From: Jones, Janet <Janet.Jones@enwl.co.uk>
Sent: 28 May 2014 14:47
To: Claire Booth
Cc: planning
Subject: Your Reference CONCS/3/2014/0395 (Contact Claire Booth) Our Reference PA1779

Erection of a new build house within garden cartilage of 58 Bushburn Drive, Langho, BB6 8EZ

PROPOSED SITE PLAN

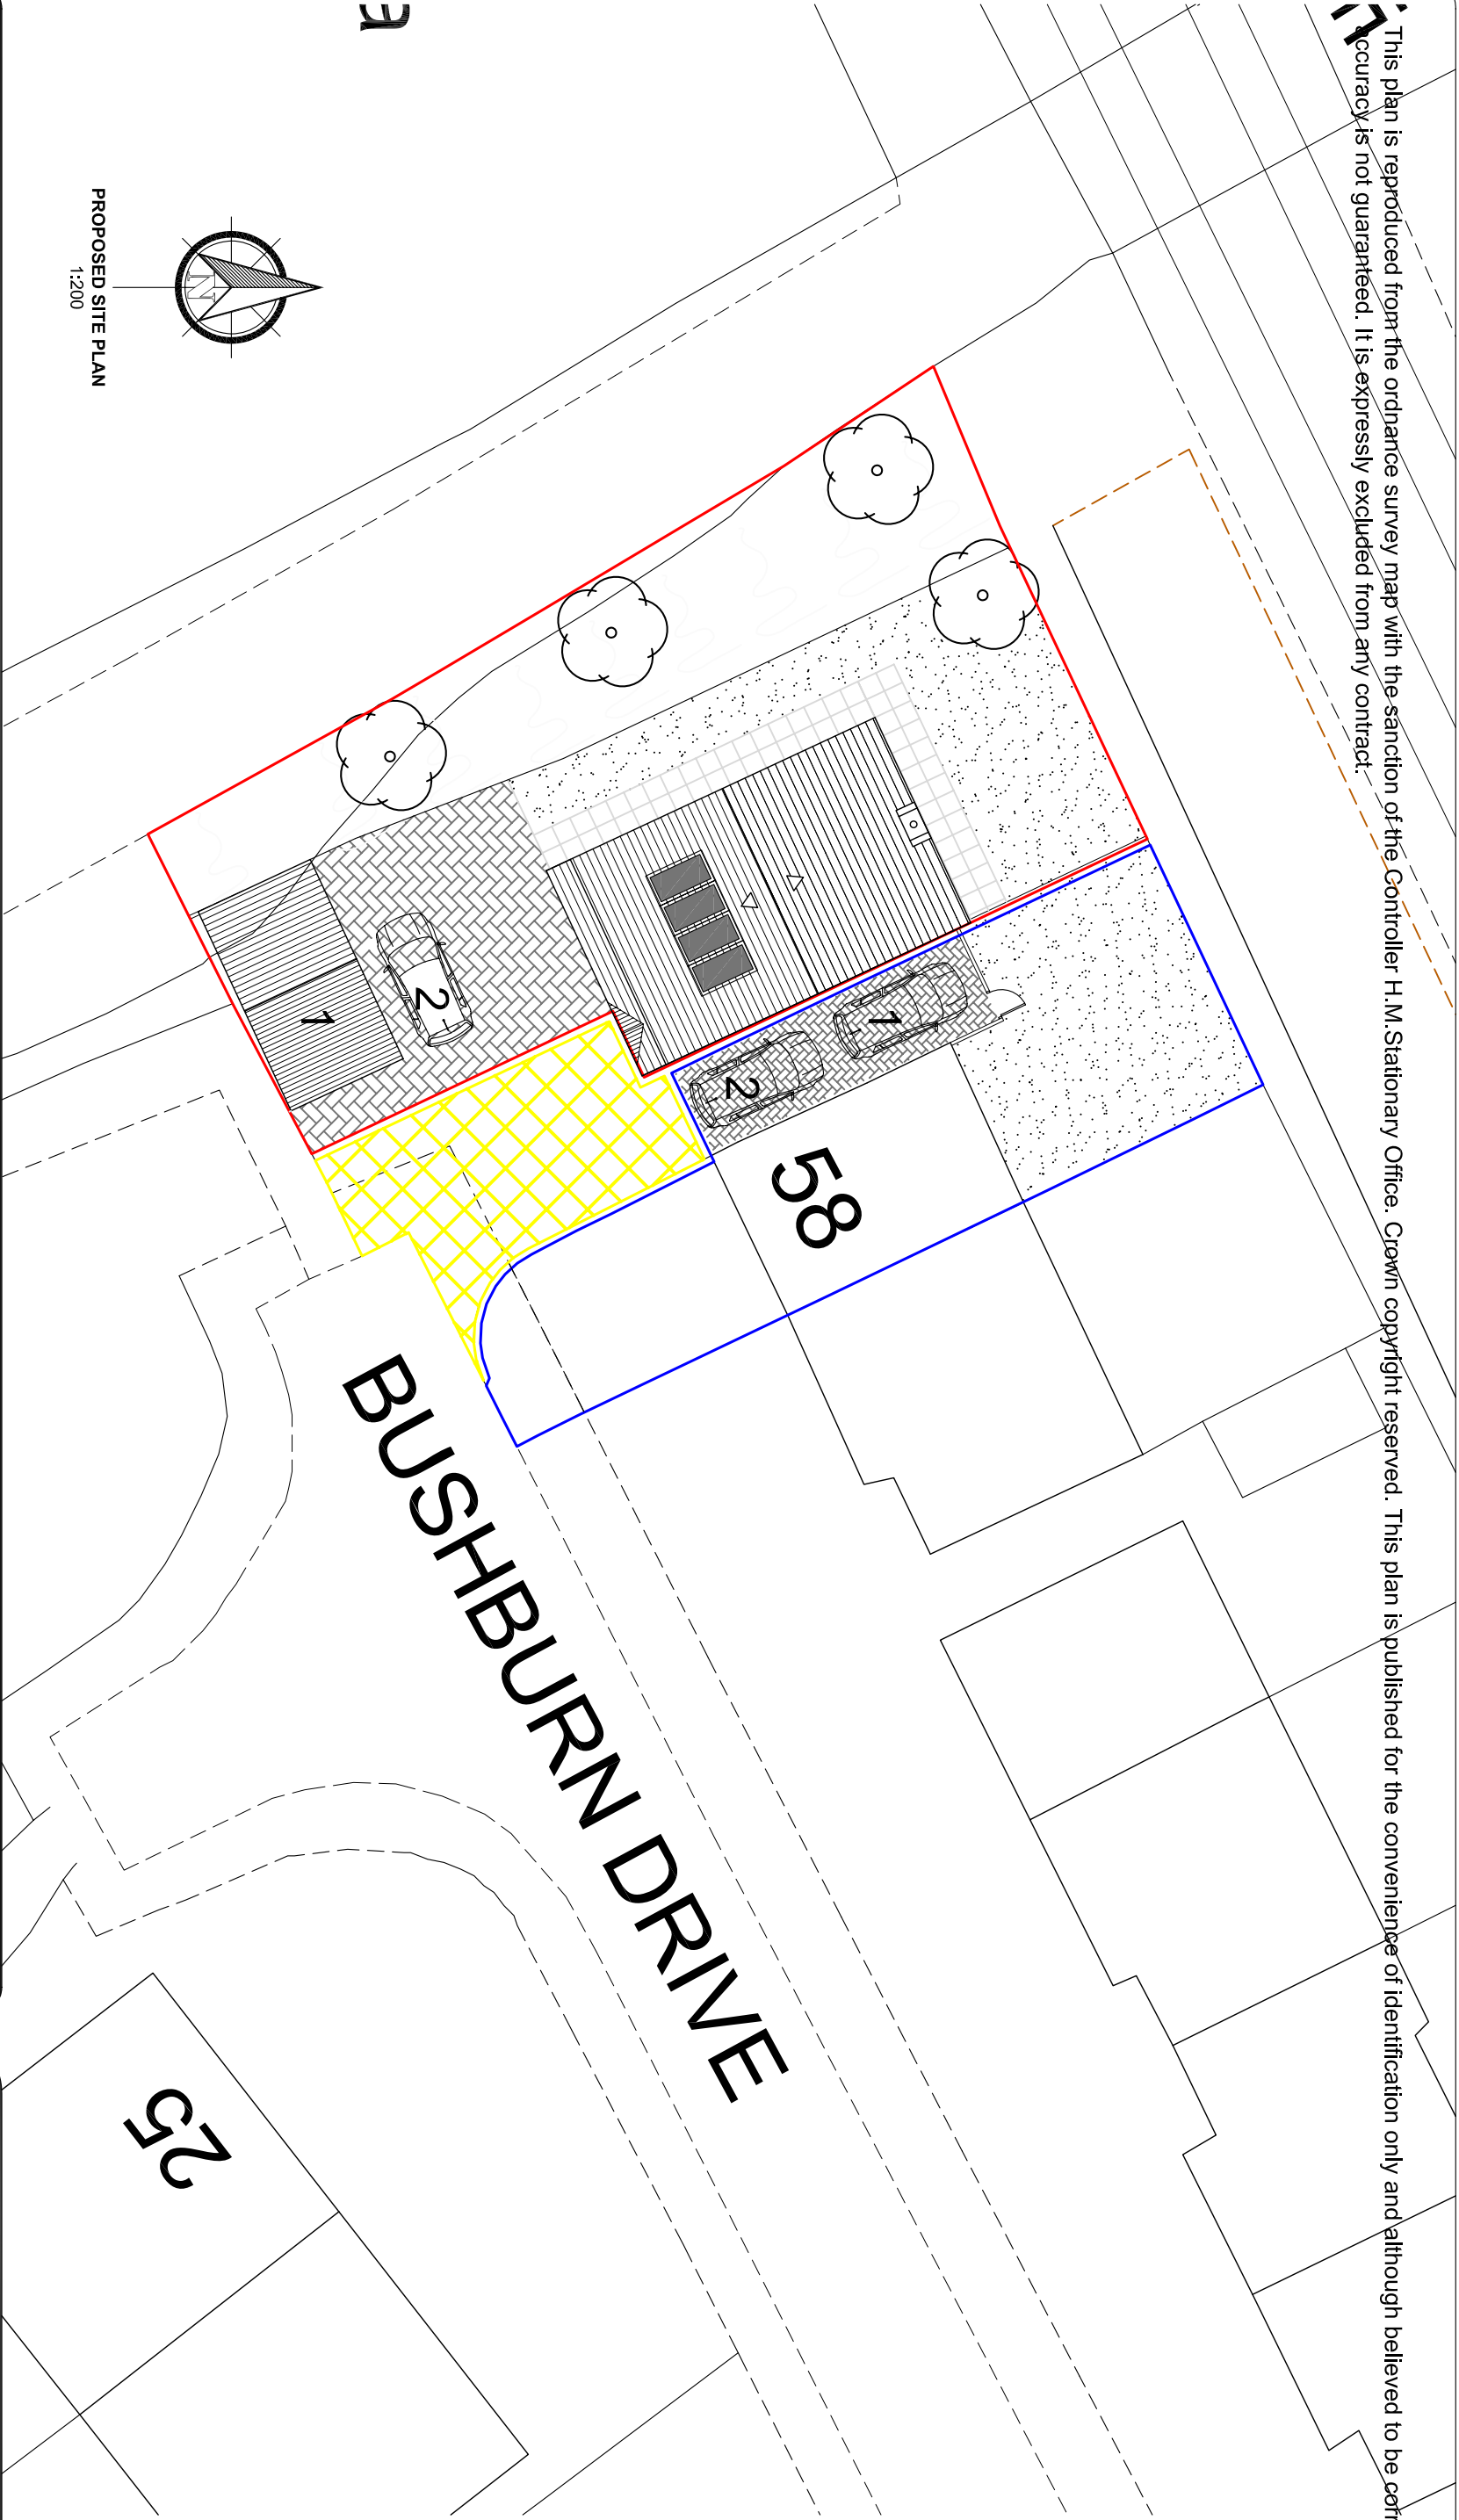
- Our records show that the proposed works will encroach on the route for a Live ENWL low voltage service cable supplying the existing building on 58 Bushburn Drive, Langho BB6 8EZ

The applicant should also be advised that, should there be a requirement to divert the apparatus because of the proposed works, the cost of such a diversion would usually be borne by the applicant. The applicant should be aware of our requirements for access to inspect, maintain, adjust, repair, or alter any of our distribution equipment. This includes carrying out works incidental to any of these purposes and this could require works at any time of day or night. Our Electricity Services Desk (Tel No. 0800 195 4141) will advise on any issues regarding diversions or modifications.
